Our Ref: EN020028

Date: 18 November 2024

Application by Morgan Offshore Wind Limited and Morecambe Offshore Windfarm Limited for an Order Granting Development Consent for the Morgan and Morecambe Offshore Wind Farms Transmission Assets project

Advice following issue of decision to accept the application for examination

Drawing Number:
BP-GBR-MORG-REG-0184

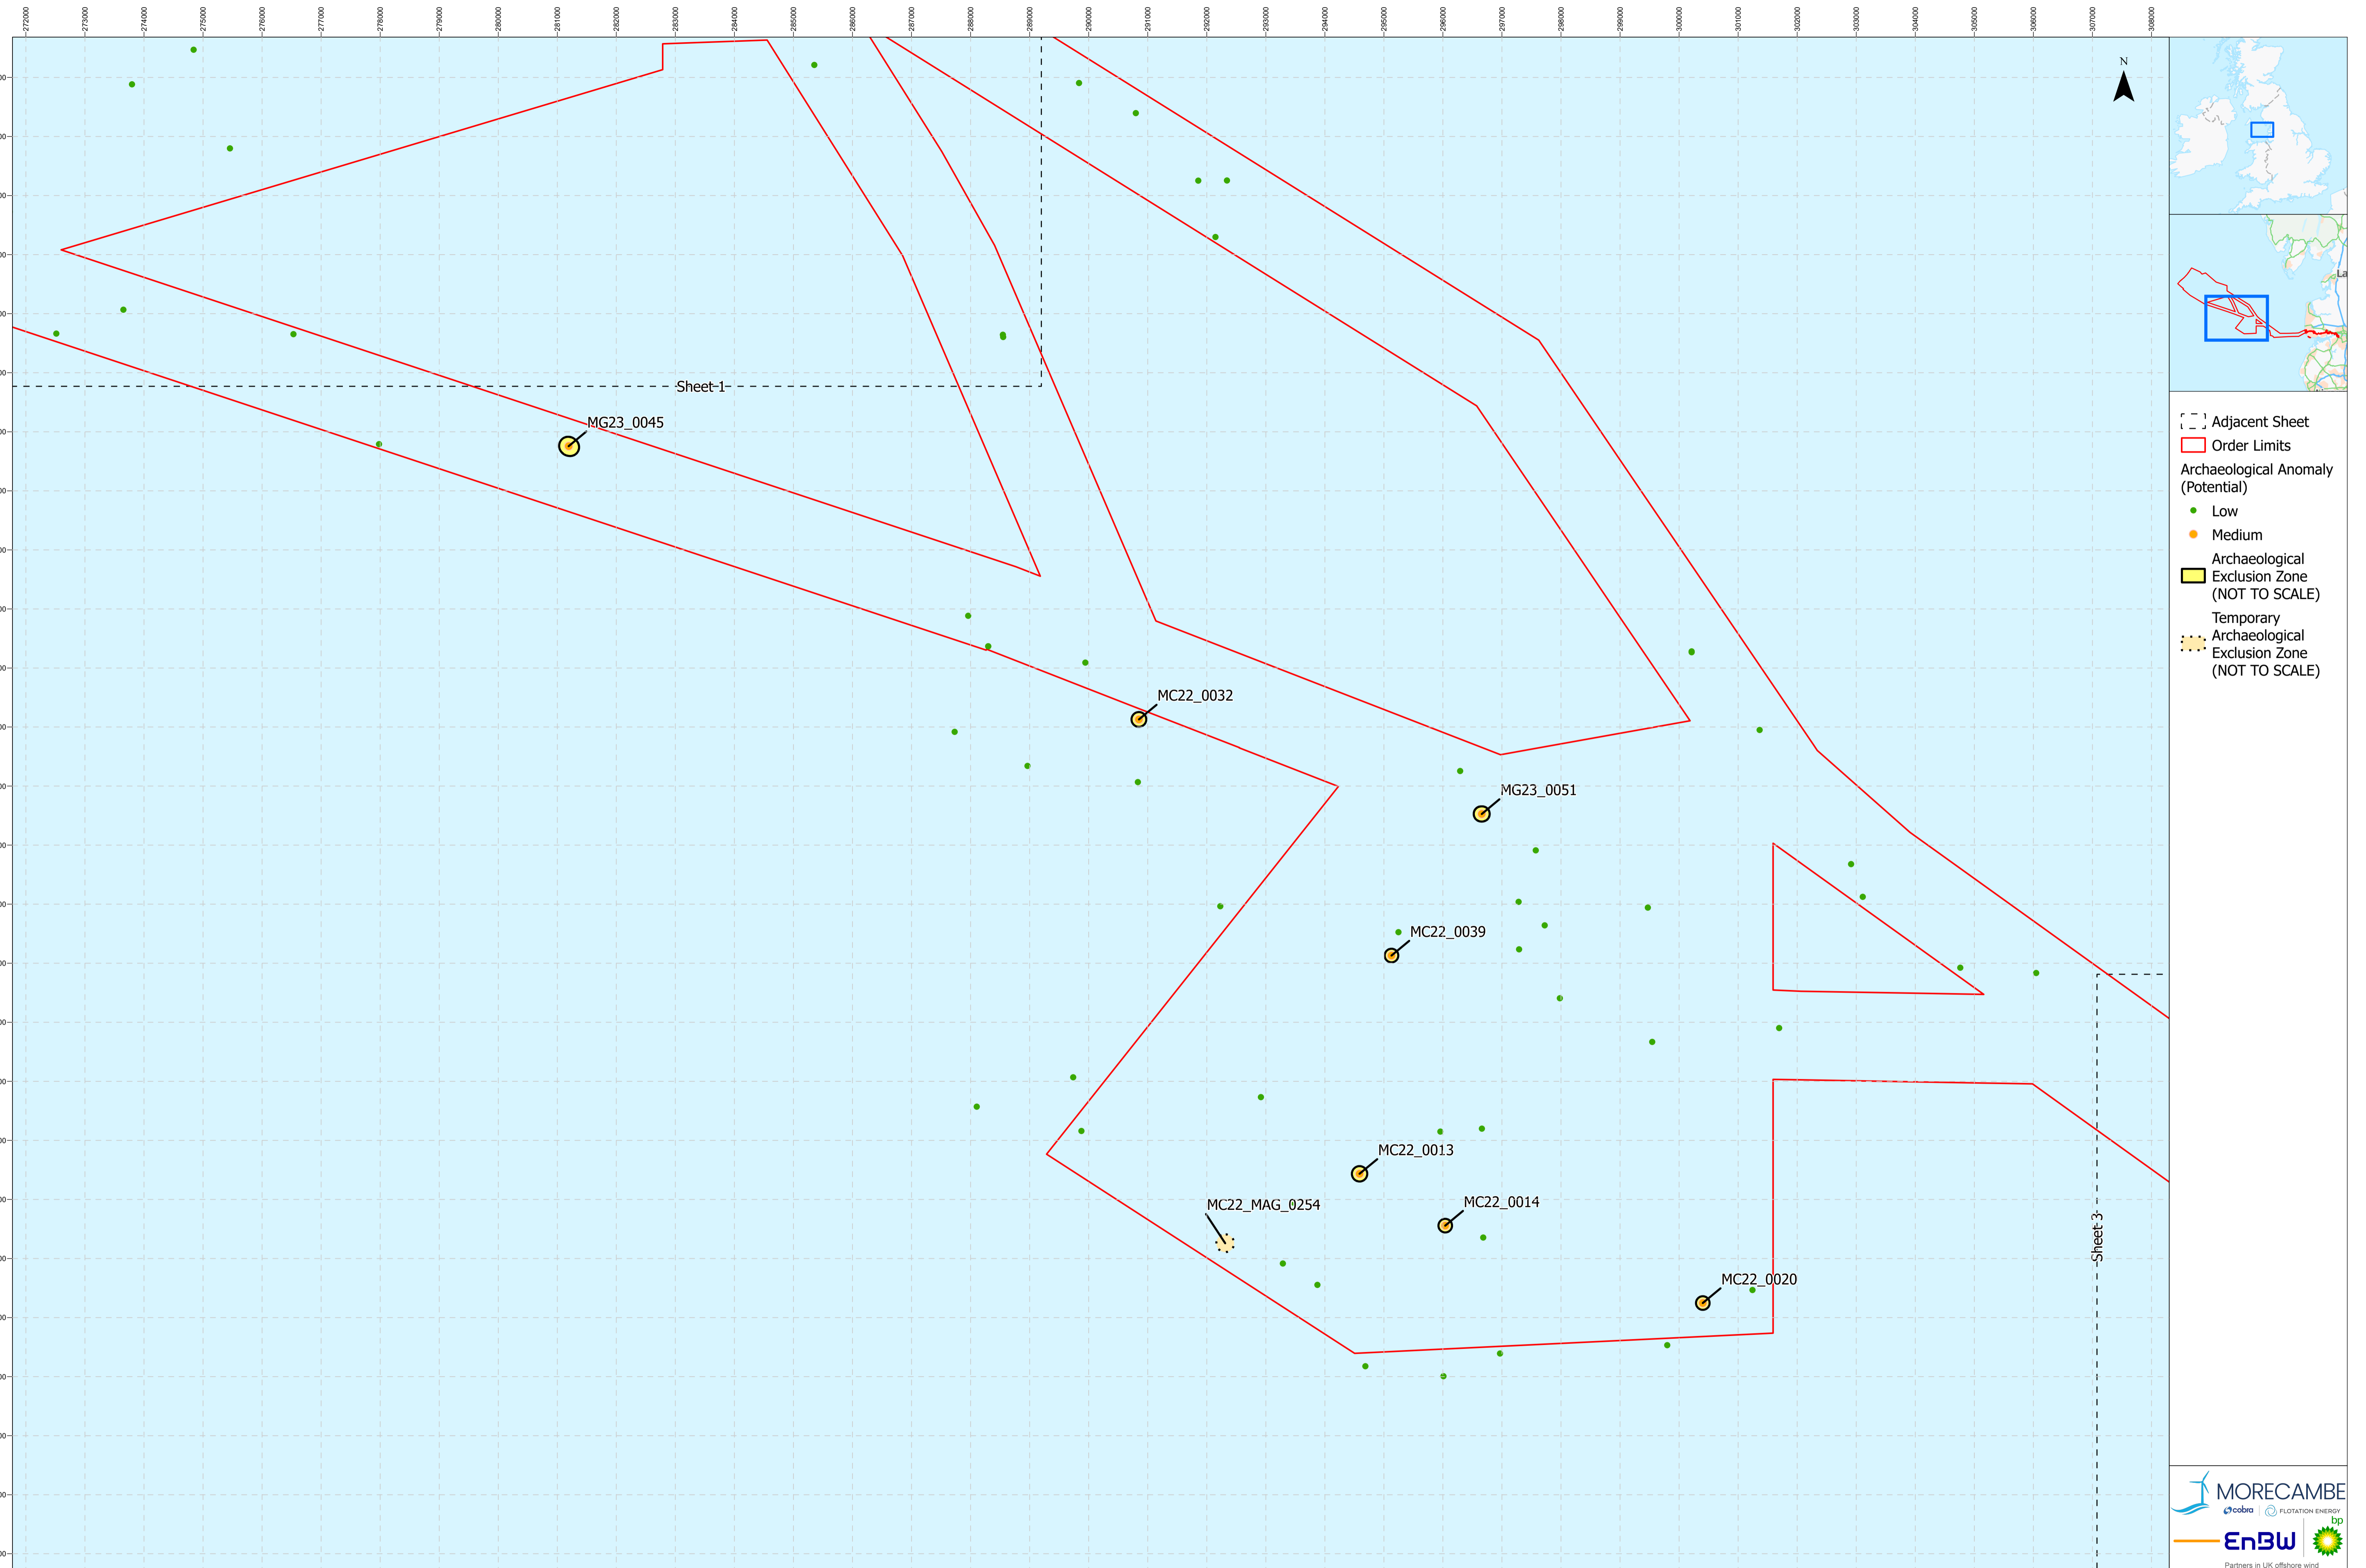
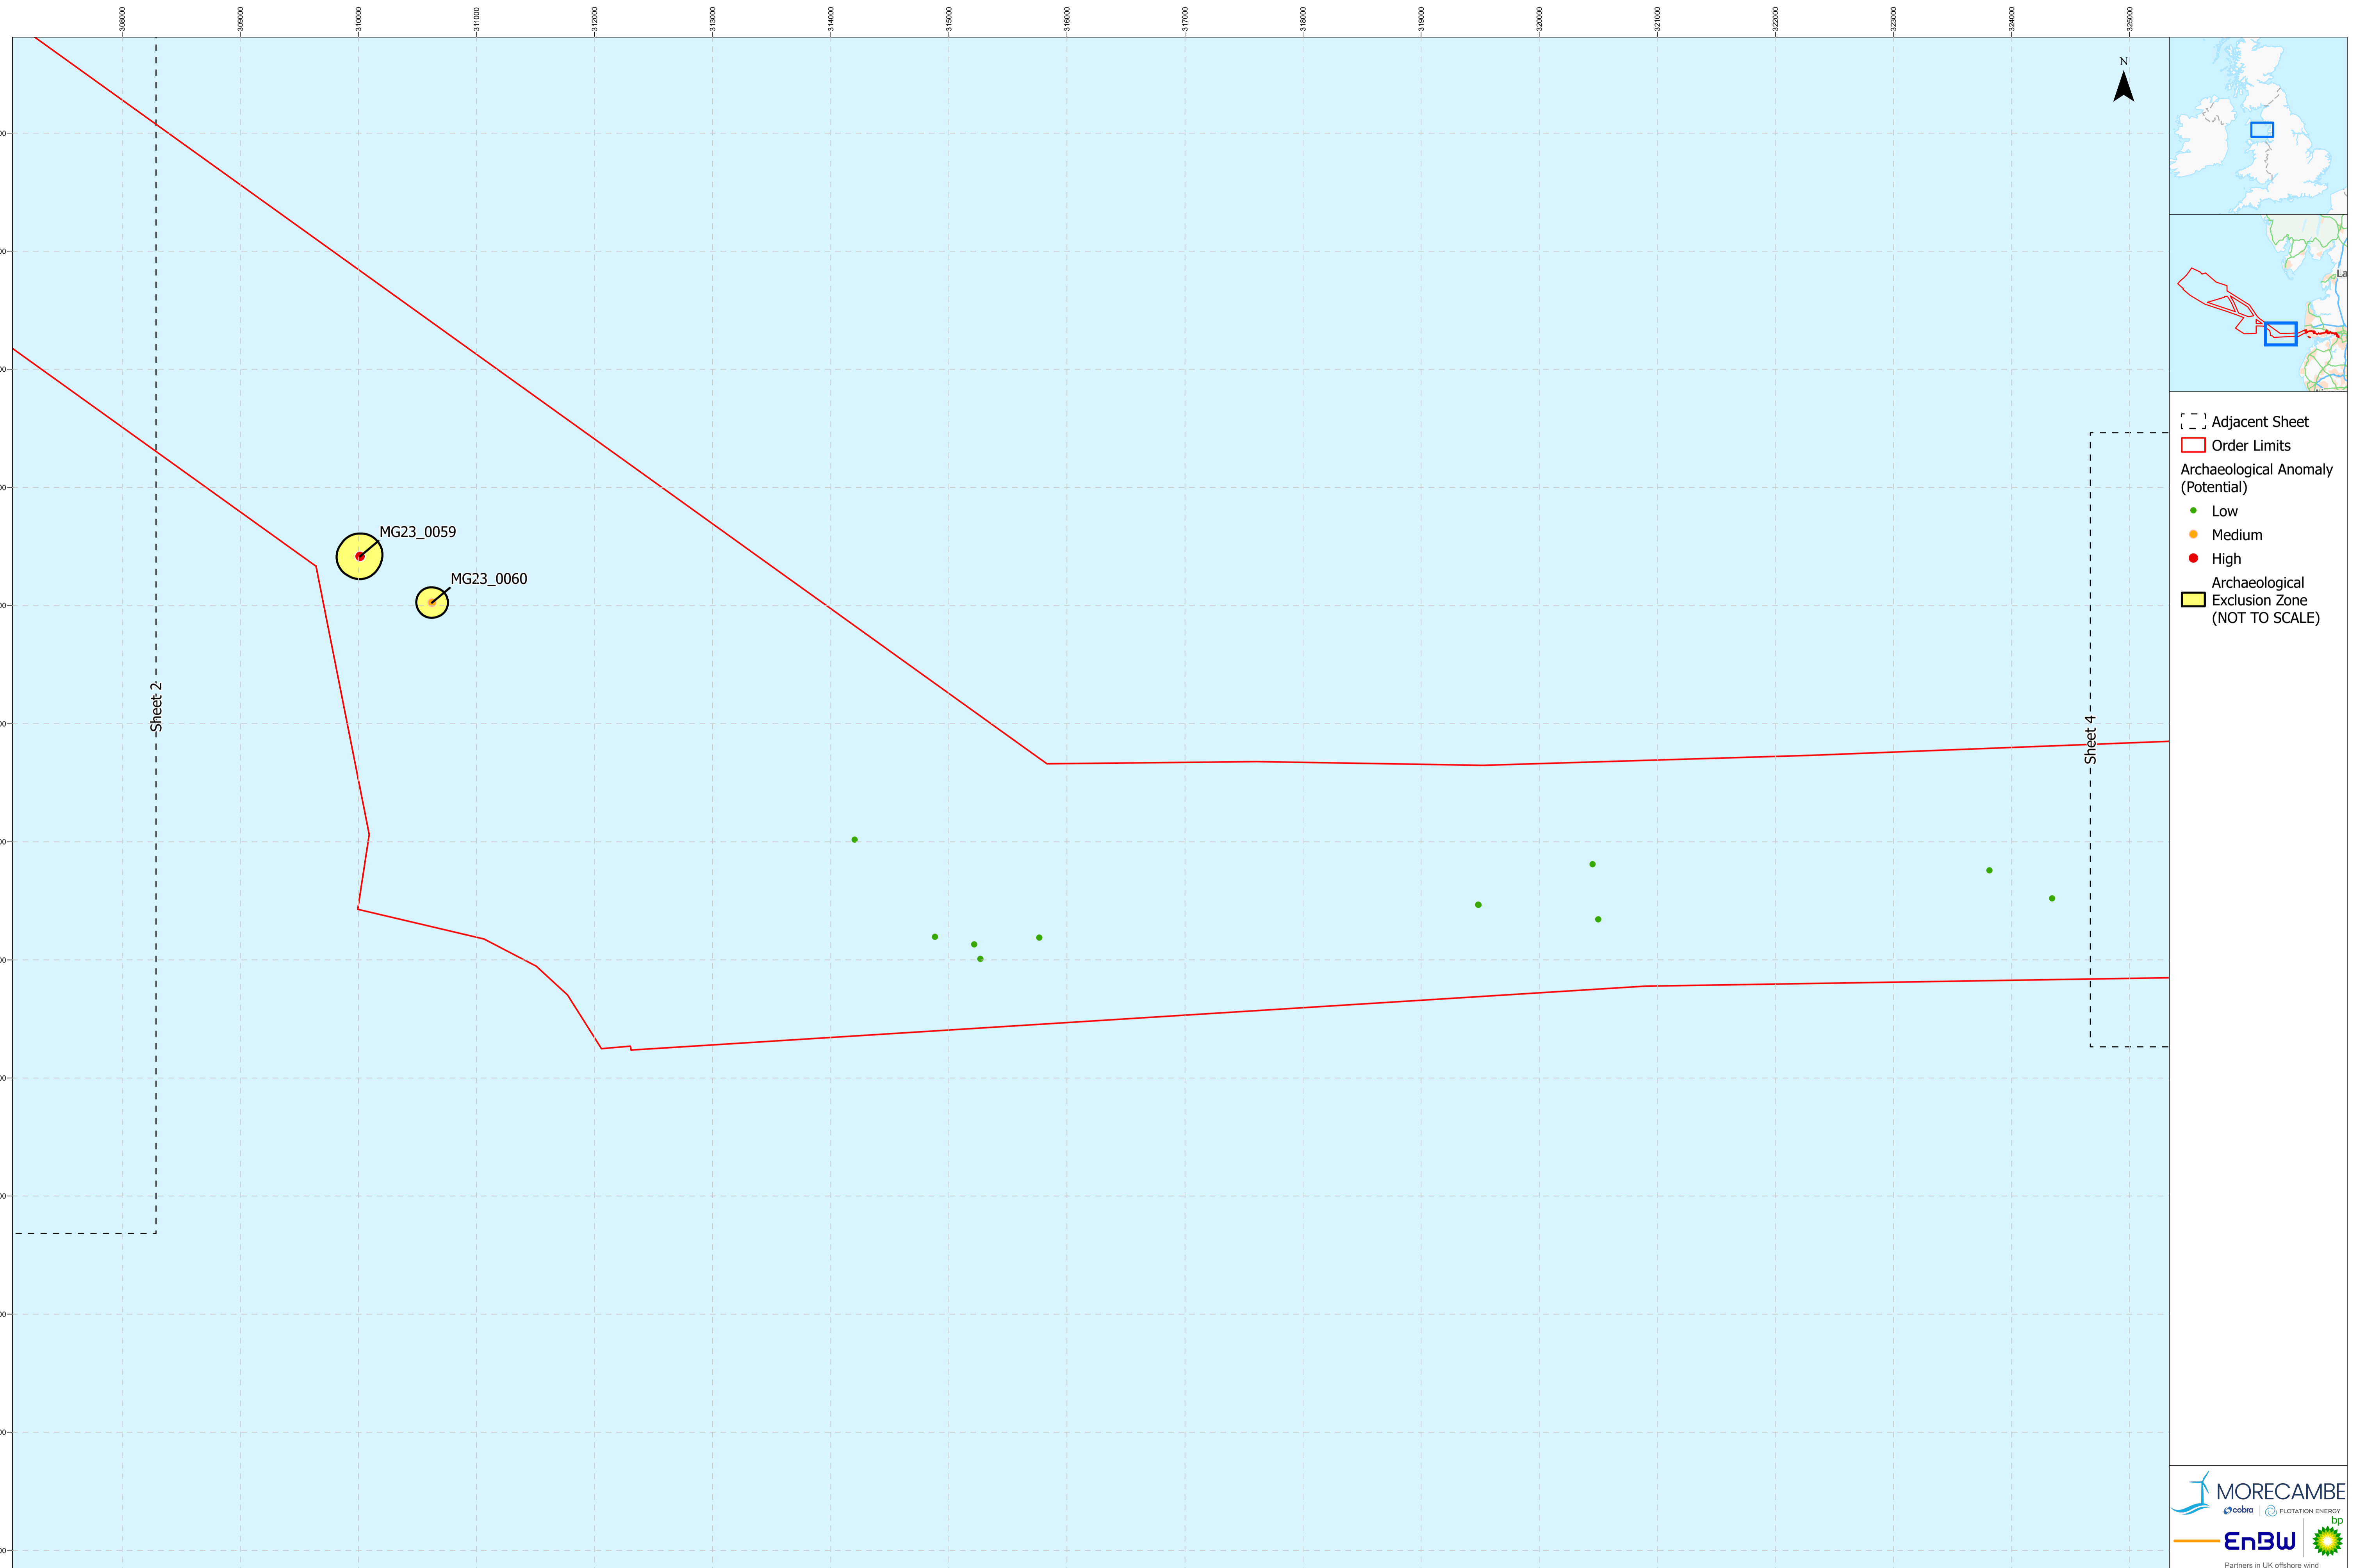
Standalone figure B17 (Statutory and Non-Statutory Features of (The Offshore) Historic Environment Plan) only shows offshore exclusion areas rather than specific features, however the specific sites are shown on the ES figures. The Applicants are advised to provide an updated set of figures with appropriate labelling of the features being represented.
